From: Elliott, Stanice
Sent: Thursday, December 22, 2016 9:17 AM
To: 'David Soule'
Subject: Coles Metal
Attachments: IMG_2012.JPG

Based upon the information provided in your submittal received 12-19-2016, the above referenced plan cannot be approved for PERM CO until the following comments are addressed:

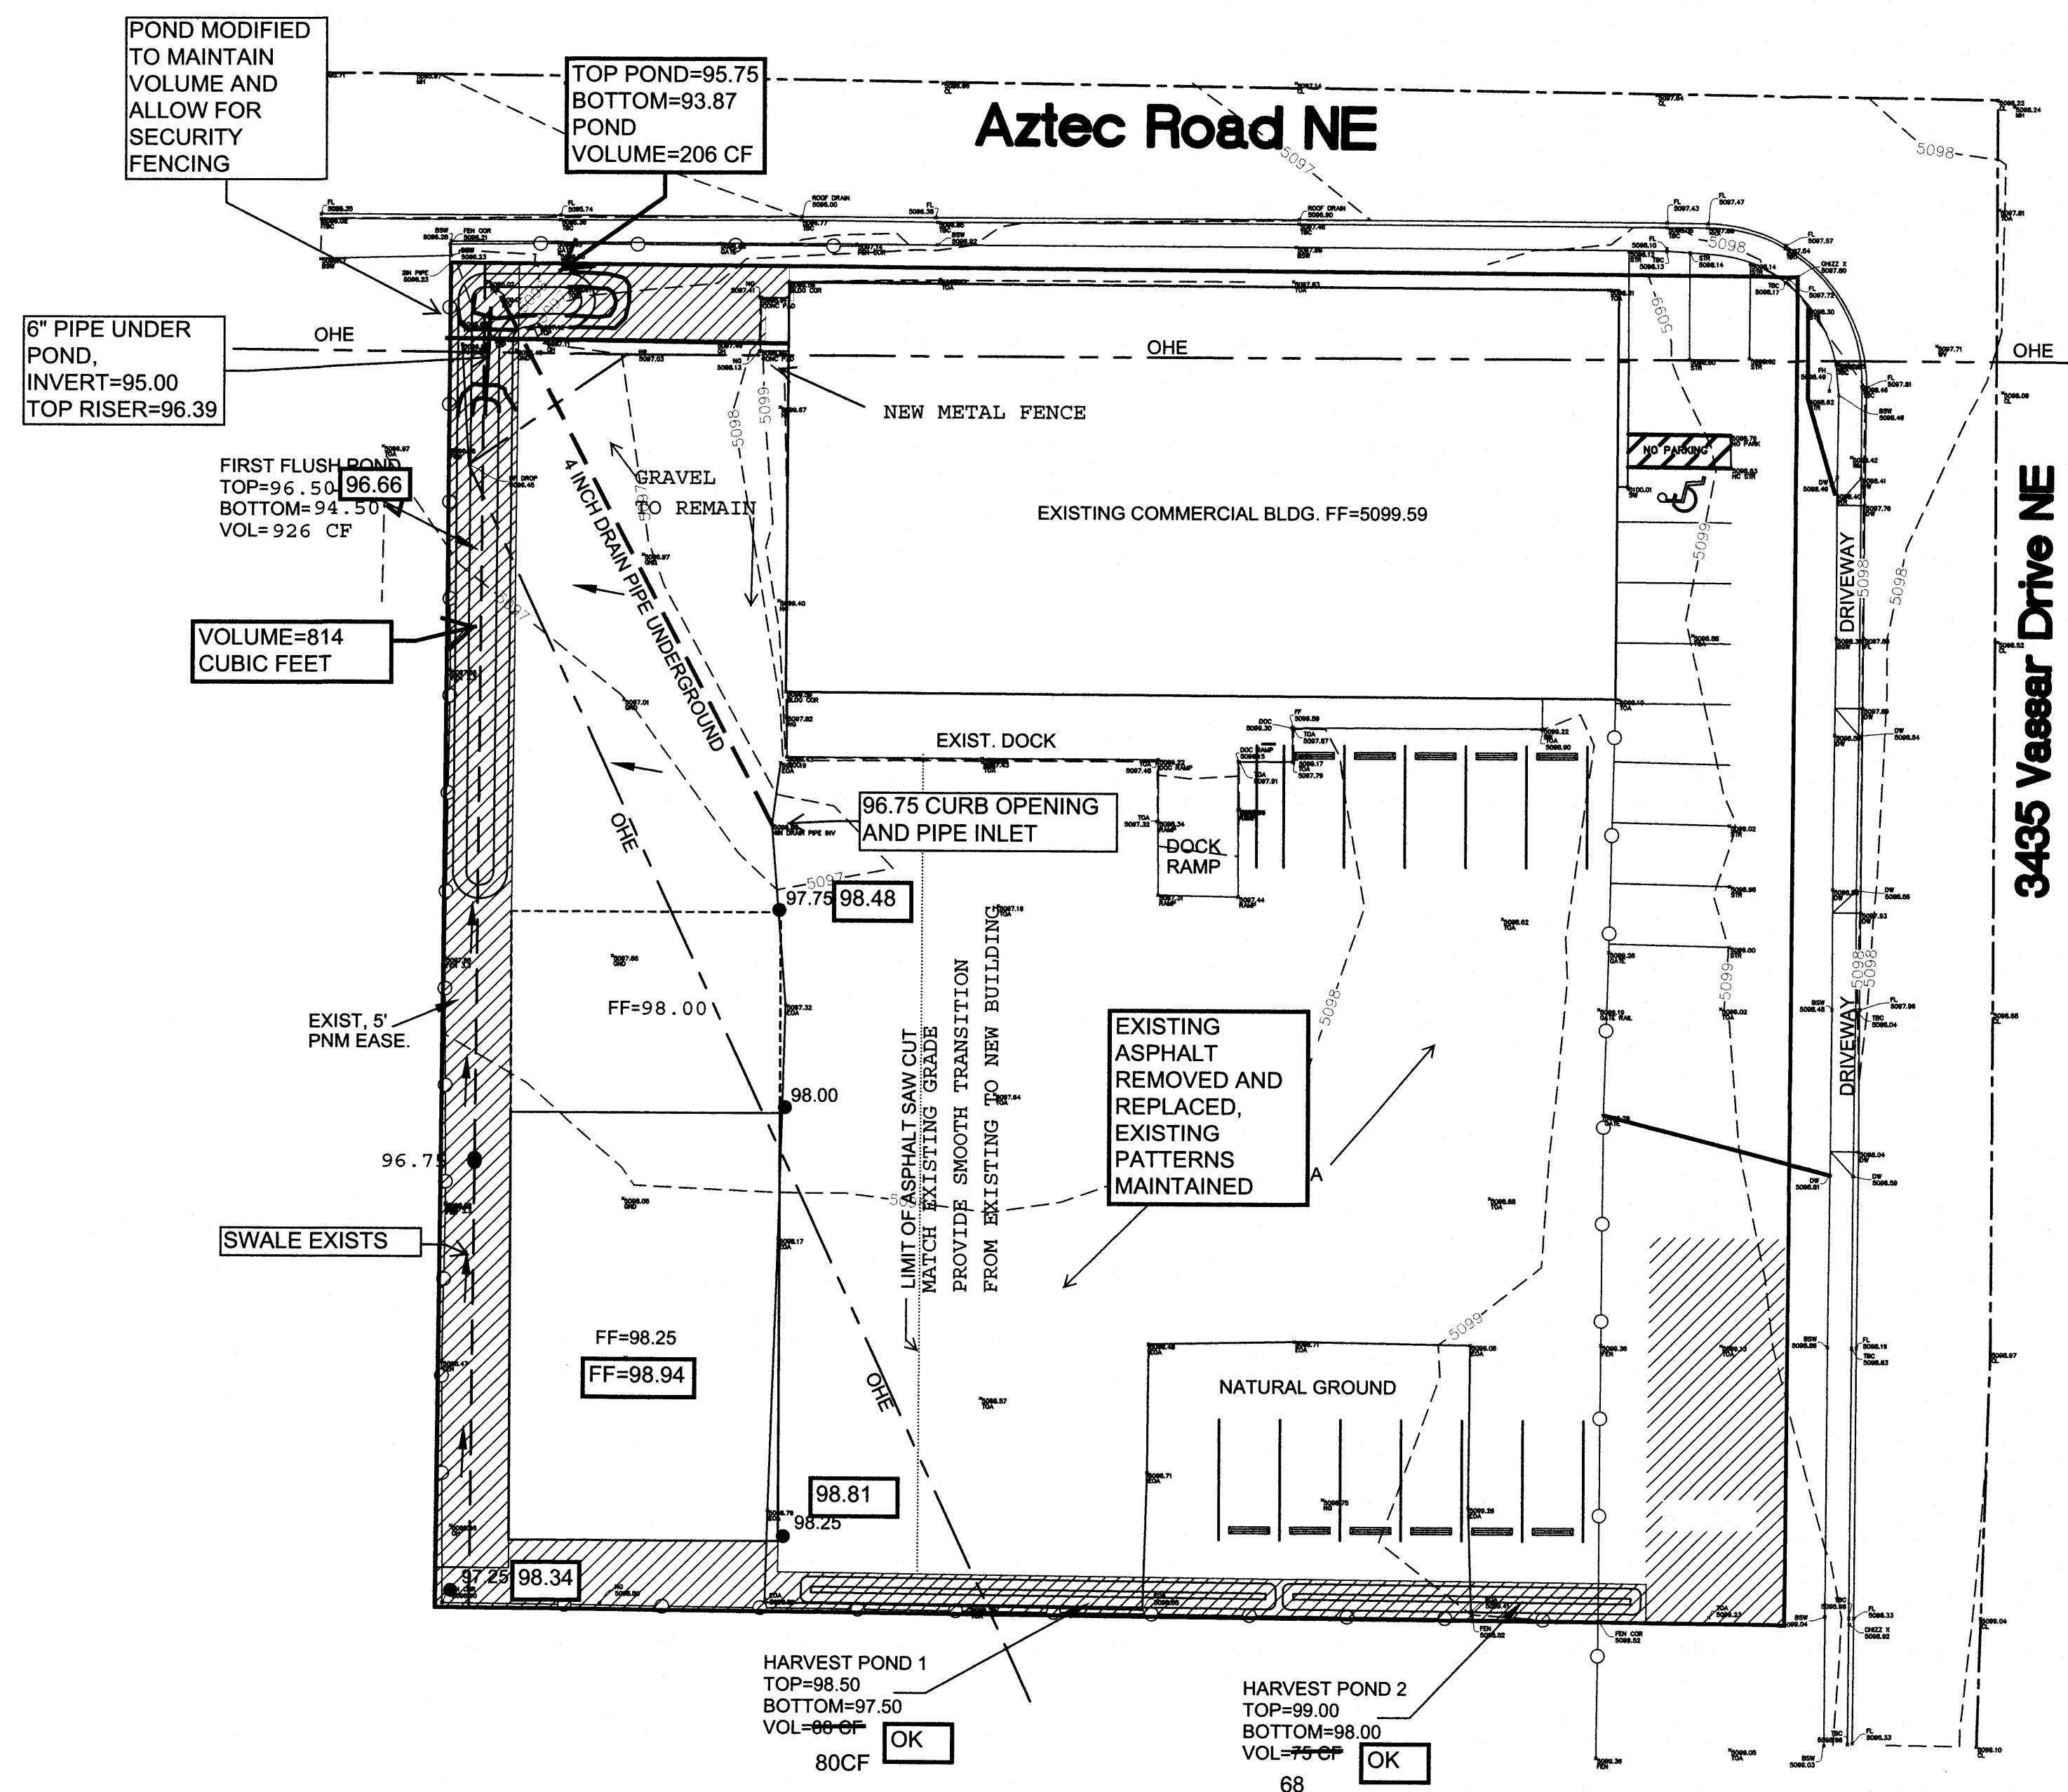
- There appears to be an outfall on the property. Pipe needs grate on top. As-built does not indicate where it flows. See attached pic.
- End of 4" pipe at NW corner in pond is covered. Unable to see.
